PORTLAND MAINE

May 19, 2011

Re: 338 Summit Street – 382 E012 – R-3 – 6' x 36' porch – permit #2011-05-1047.

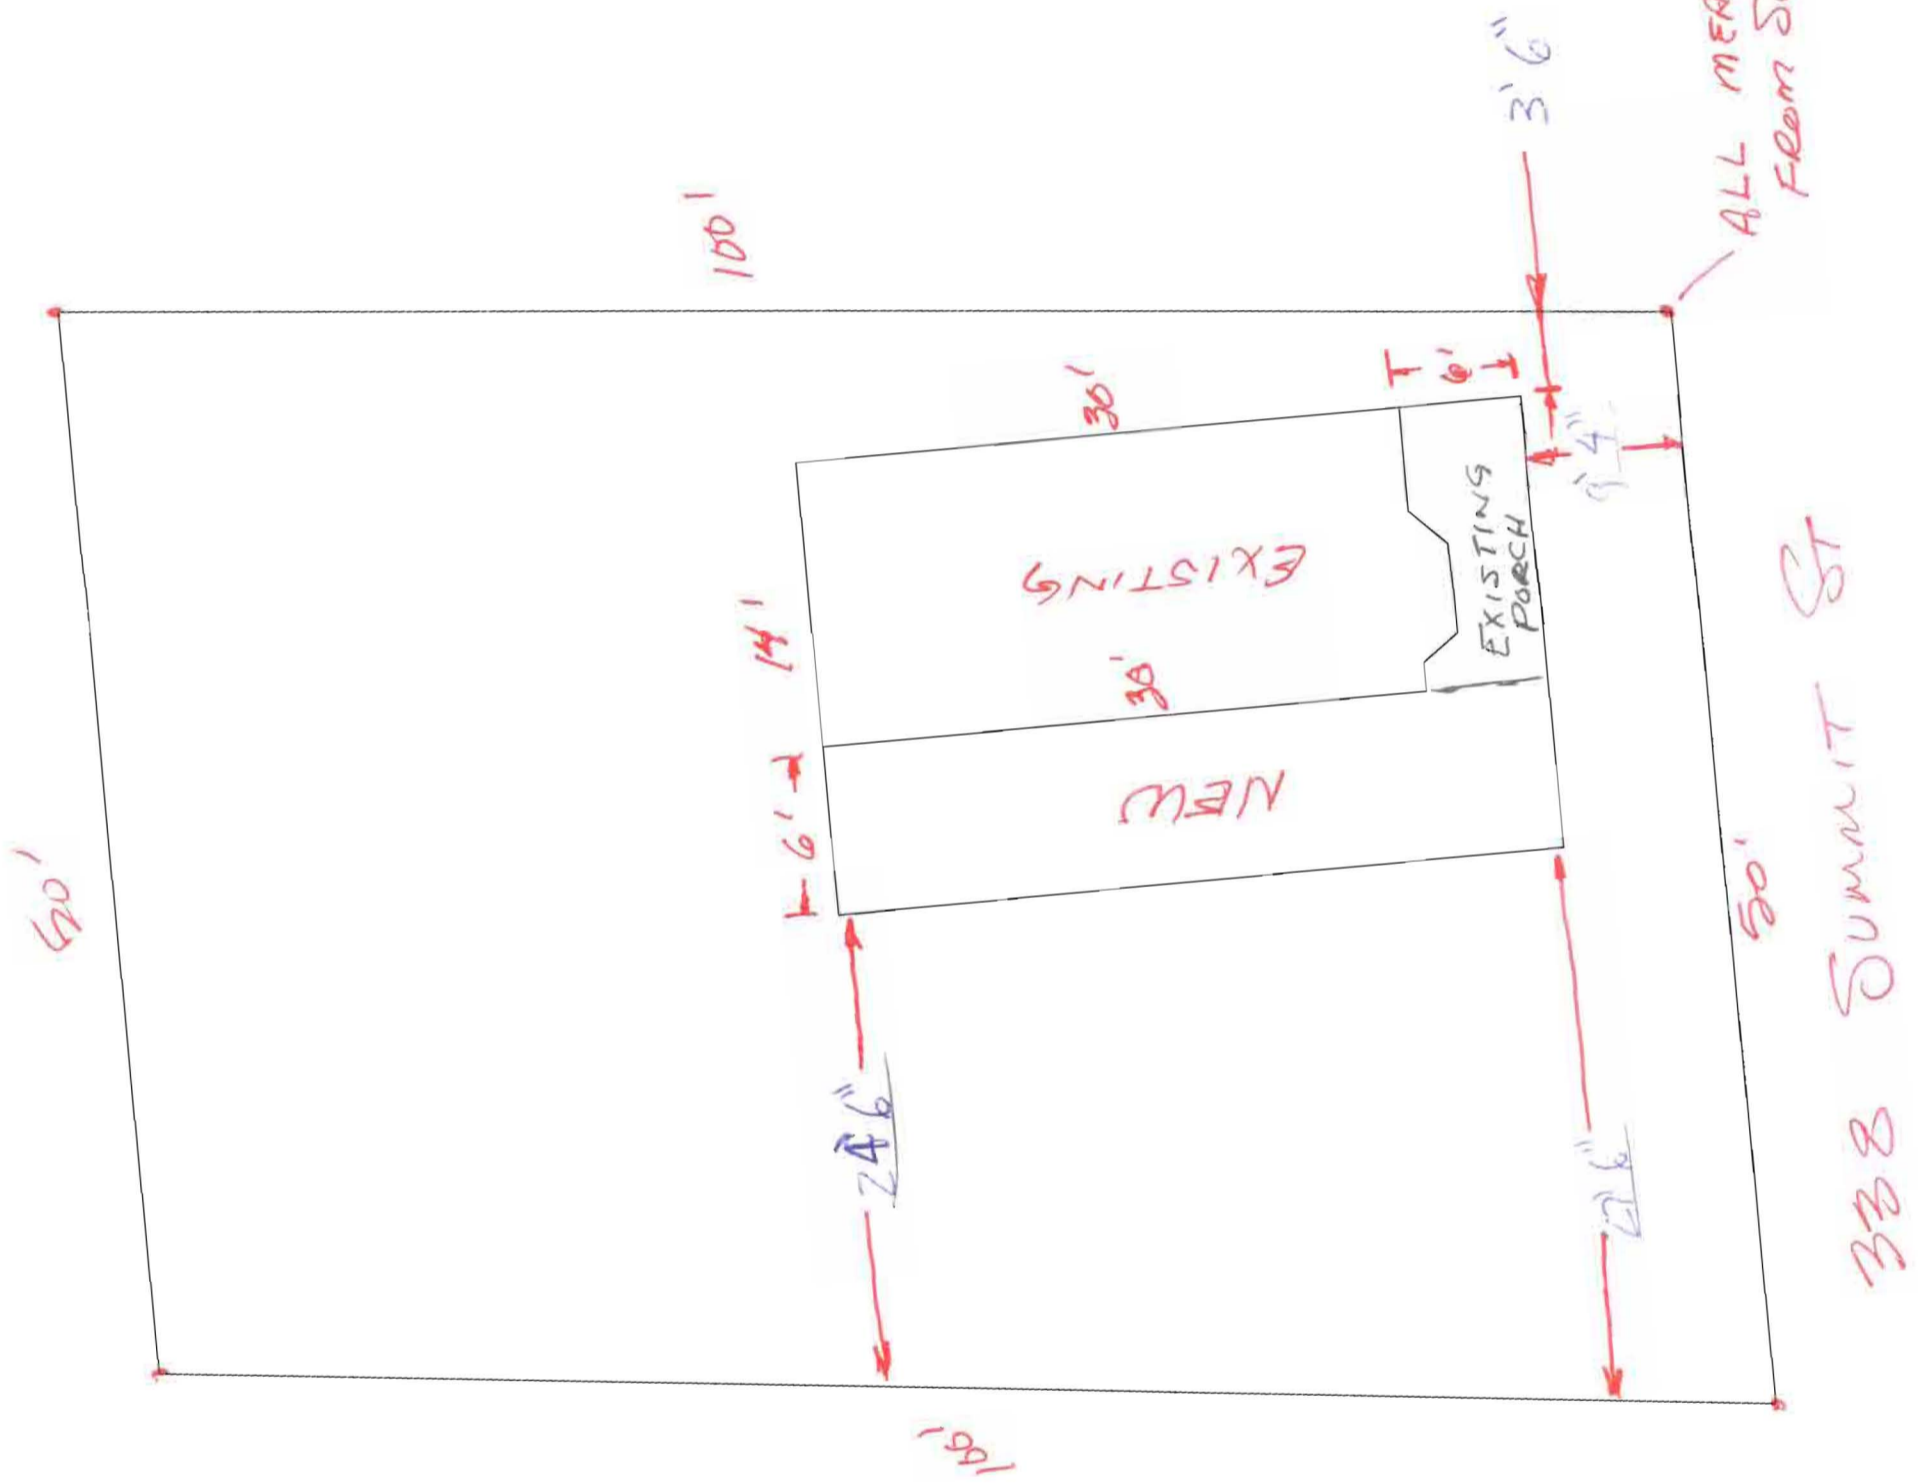
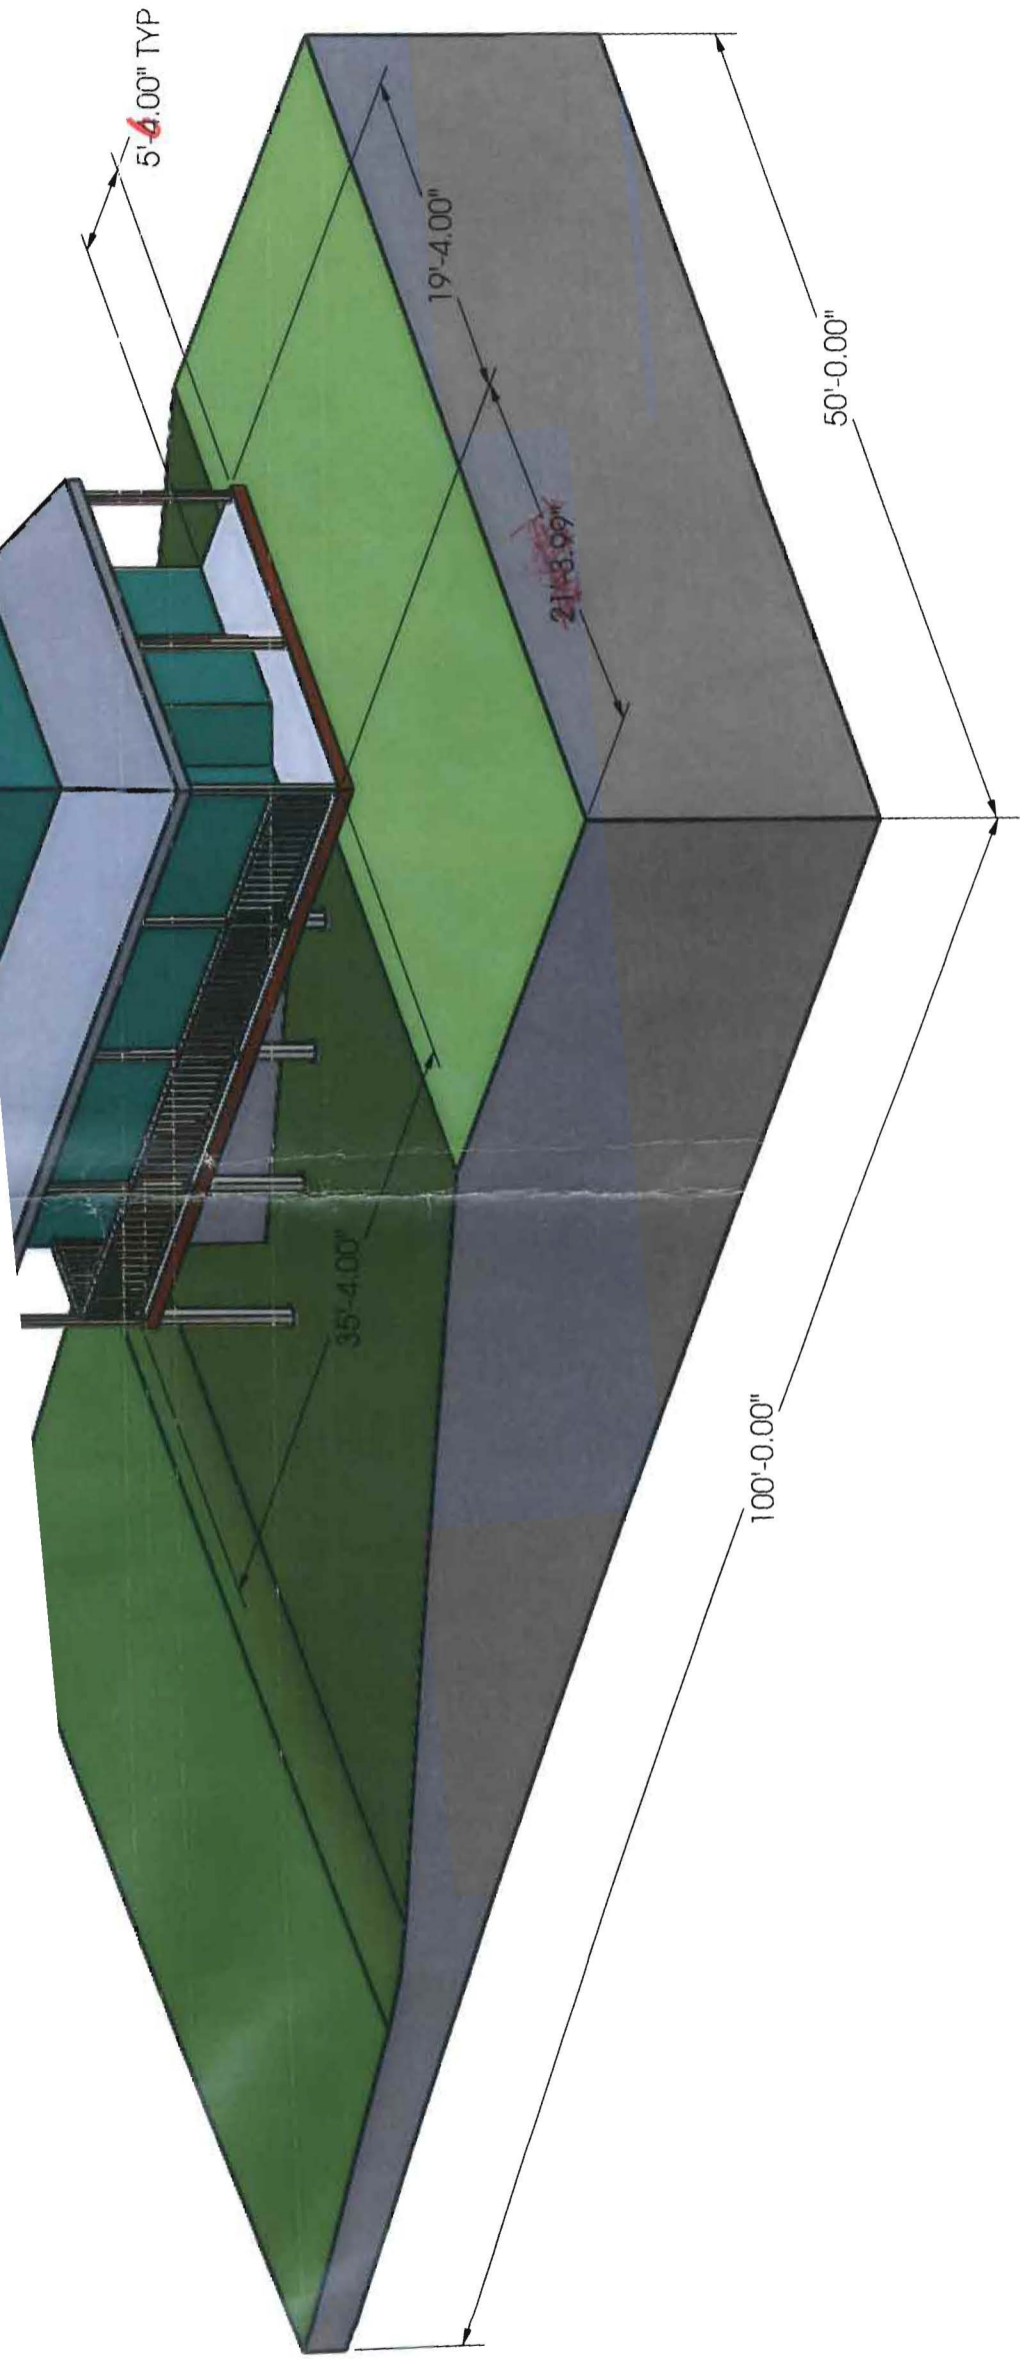
338 Summit Street is located in the R-3 residential zone. The required front setback in the zone is twenty-five feet [Section 14-90(d)(1)]. The plot plan shows the front setback to the proposed addition as 9'4". Since it does not meet the required setback, the permit is denied.
